Our Ref: OUTL/21/003

Transport for London
City Planning

31 March 2021

The London Resort, Swanscombe and Tilbury: TfL's relevant representation

Figure 3-1: Strategic Model Extent (Including Lower Thames Crossing)

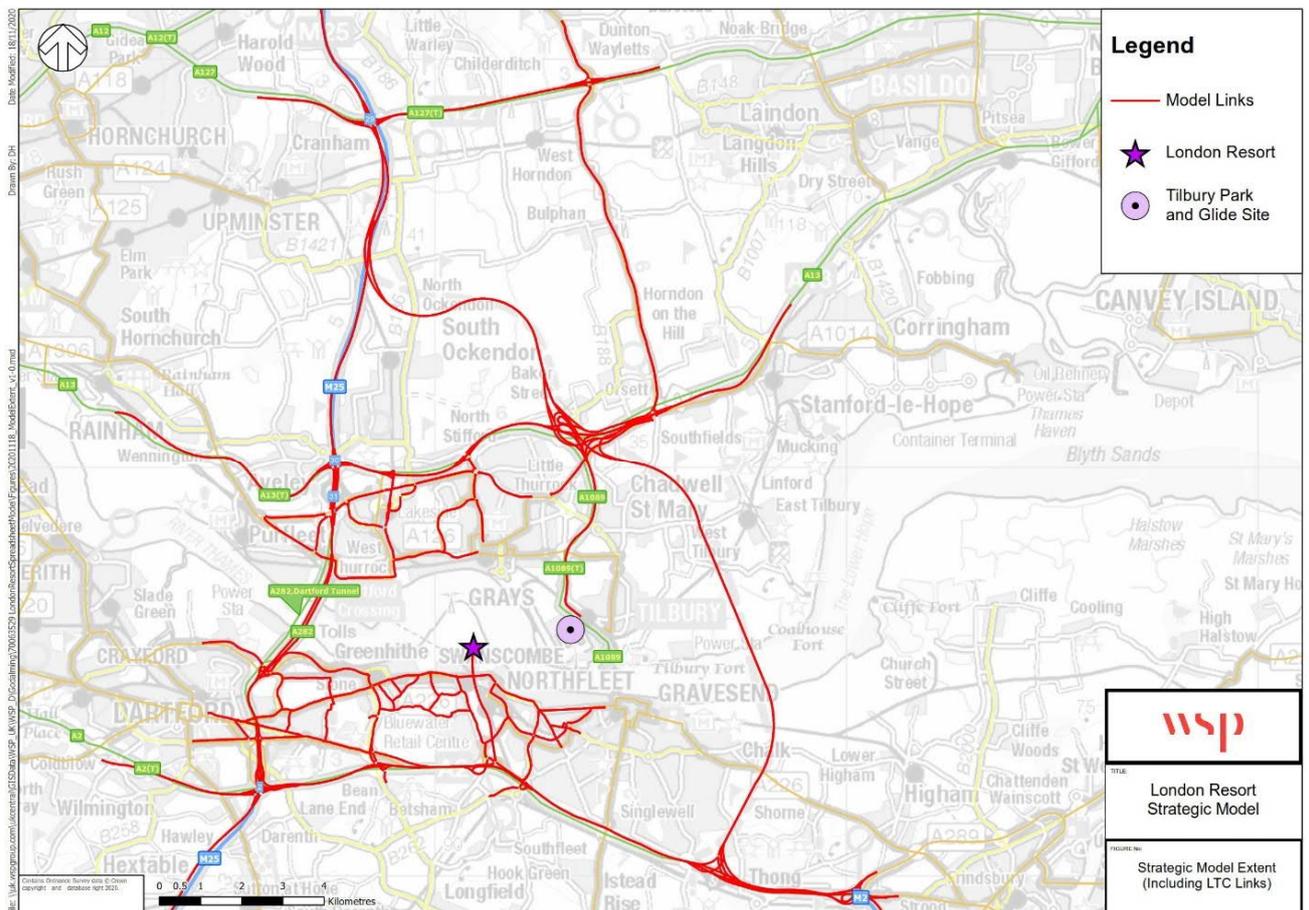
The M25, the Dartford Crossings and other parts of the strategic road network in this area already suffer from congestion for extended periods. The use of a spreadsheet model is totally inadequate for assessment of the impact of additional flows since it cannot effectively model the congested nature of the network and the diversionary effect that will result. We anticipate that flows from the Proposed Development, especially in the “without Lower Thames Crossing” scenarios, are likely to lead to diversion of traffic onto TfL’s strategic road network, including alternative river crossings such as Blackwall and Silvertown Tunnels, in addition to traffic generated to/from London itself. The spreadsheet model does not appear to consider any junctions inside the area bounded by the M25.

Further, consideration of one single weekday morning and evening peak hour does not recognise the fact that, in part due to the congested nature of the highway network, the existing peak period lasts considerably longer than a single hour. We believe it is necessary to consider the superimposition of forecast vehicle movements onto background flows throughout the day to determine whether a new network peak is created. As noted above, weekends and bank holidays should be considered.
